Application no: H04/0114/98

Description: Ground floor extensions and alterations.

Amendment: Additional ground floor bedroom omitted, garage modified
Drawing No. B1/1/98A

**TOWN AND COUNTRY PLANNING ACT 1990
NOTICE OF ACCEPTANCE OF AMENDMENT**

LAYOUT PLANS.

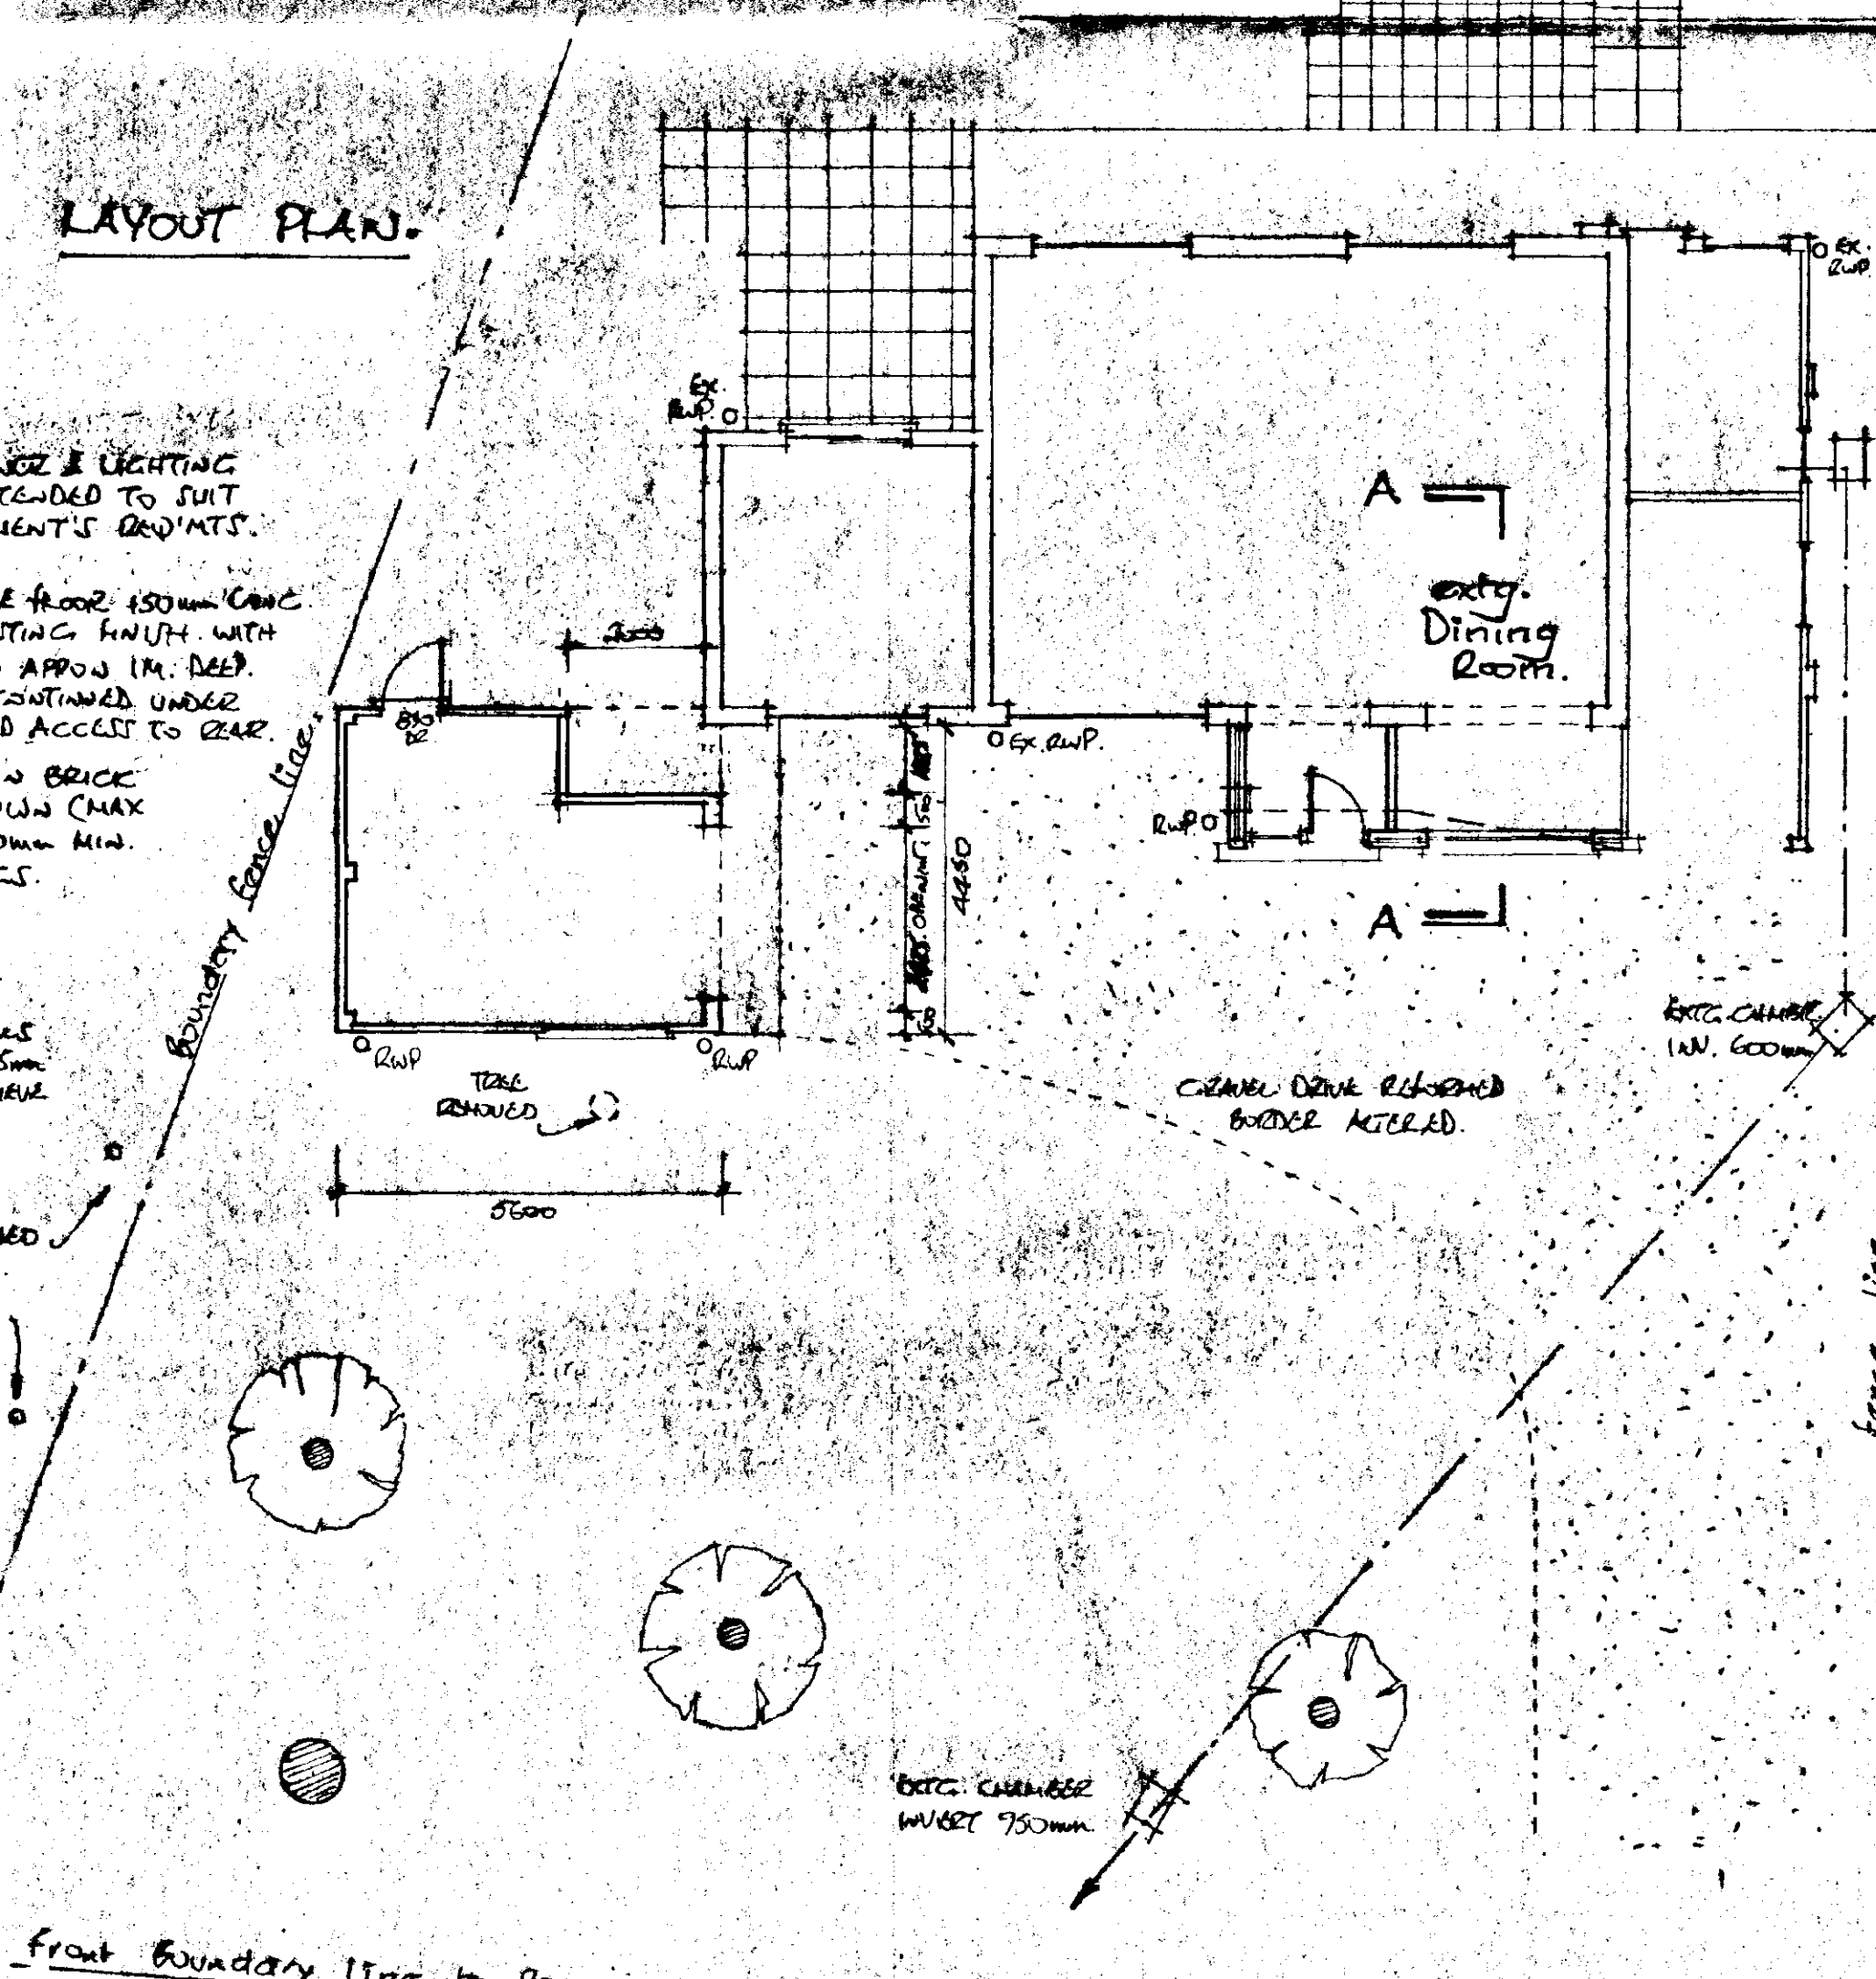
ADDITIONAL G.L.R. BEDROOM
UNITED. GARAGE MODIFIED.
(DRAWING NOTED & NOTED
ATTACHED TO PLAN).

ADDITIONAL BEDROOM UNIT
